**RE: 1600 First Street Northwest, Loading Dock Remodel
Revised Grading and Drainage Plan
Engineer's Stamp Date 2-5-16 (File: J14D178)**

**RE: 1600 First Street Northwest, Loading Dock Remodel
Grading and Drainage Plan
Engineer's Stamp Date 12-22-15 (File: J14D178)**

**RE: 1600 First Street Northwest, Loading Dock Remodel
Grading and Drainage Plan
Engineer's Stamp Date 12-15-15 (File: J14D178)**

GRADING AND DRAINAGE PLAN

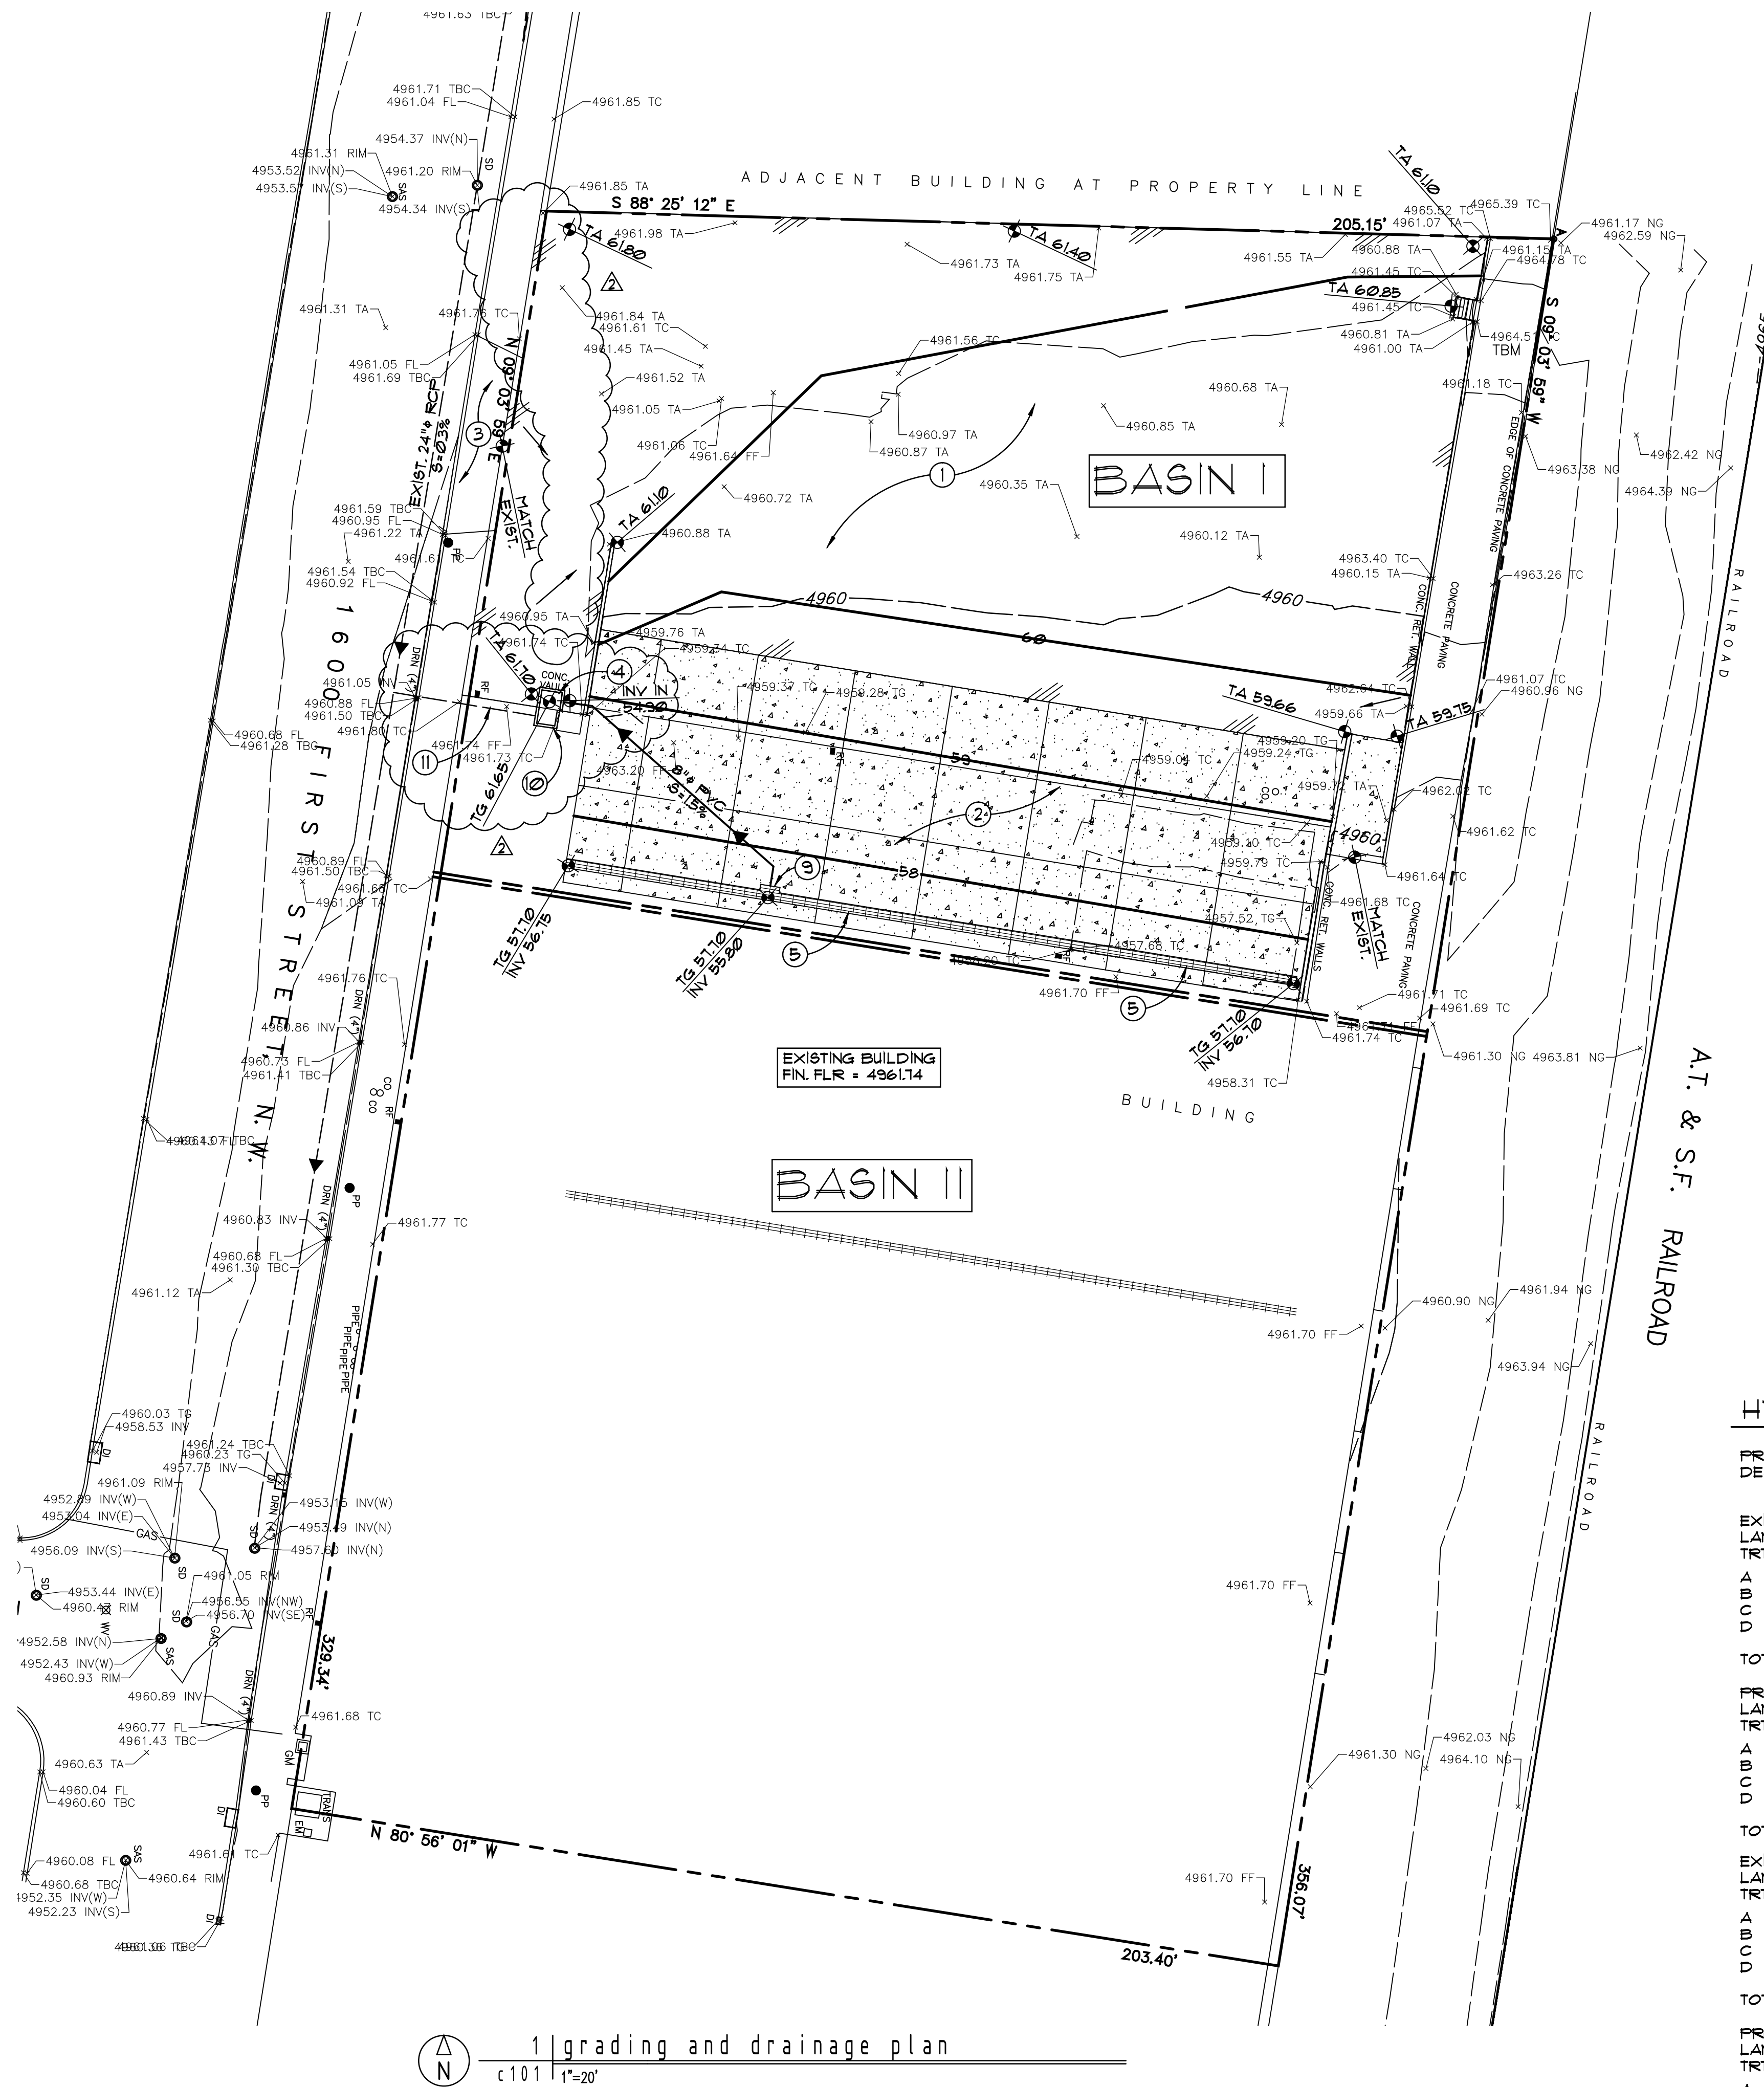
Based upon the information provided in your submittal received 2-5-16, the above-referenced revised plan is approved for Building Permit (SO-19 is no longer needed in this revised plan).

Please attach a copy of this approved plan in the construction sets when submitting for the building permit. Prior to Certificate of Occupancy release, Engineer Certification per the DPM checklist will be required. Please ensure that the existing piping under the sidewalk is completely cleaned.

GRADING AND DRAINAGE PLAN

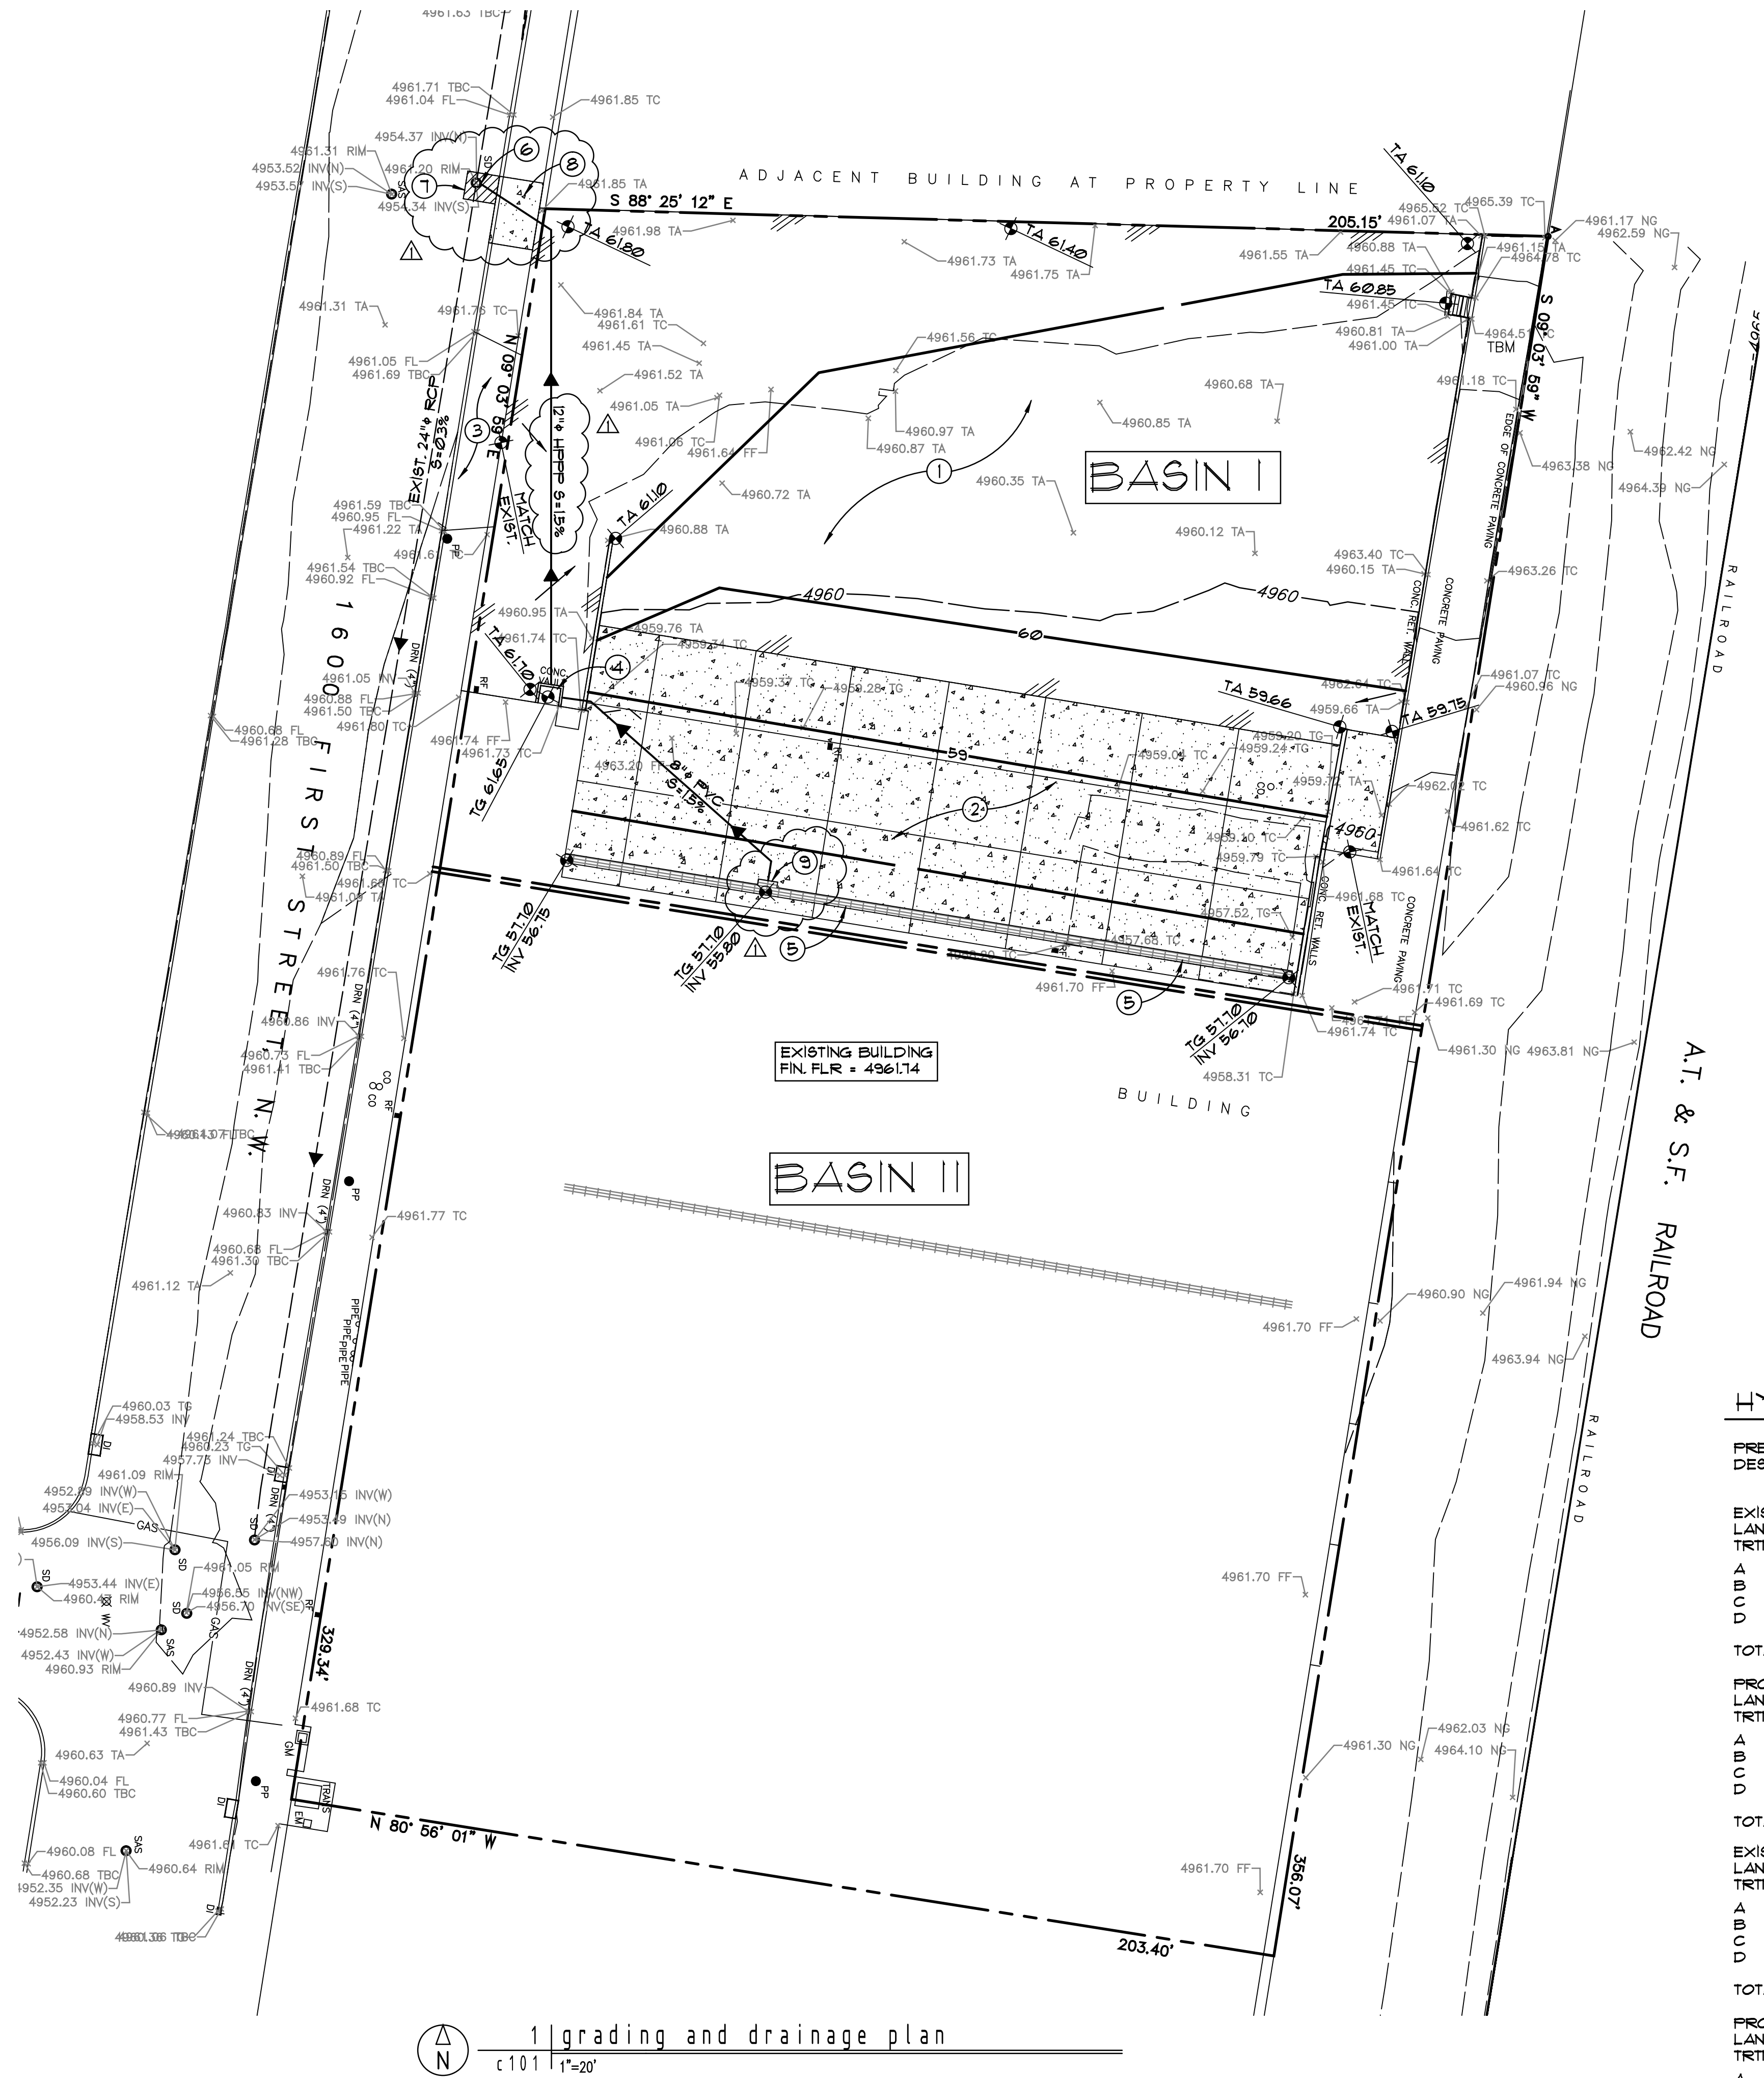
1. The on-site management of the first flush is required for all reconstruction projects, <https://www.cabq.gov/planning/documents/SignificantDrainageOrdinanceChanges0414.pdf>. At a minimum, for this site, an oil/water separation feature should be included prior to discharging to the city's storm drain system (or to the pumping station).

The work within First Street Right of Way will require a Special Order-19 ("SO-19"); the following items will need to be addressed for that approval:

2. The pipe segment within the right of way will need to be a minimum 12" diameter RCP or HPPP (High Performance Polypropylene Pipe).

3. Typically, bends are not allowed along the storm drain within City Right of Way, and a manhole would need to be installed. However, given the proximity of the proposed connection, it seems unfeasible to construct a new manhole between the back of curb and the building. Instead, please flatten the angle of the bend under the sidewalk as much as possible by adjusting the property line crossing point of the line.
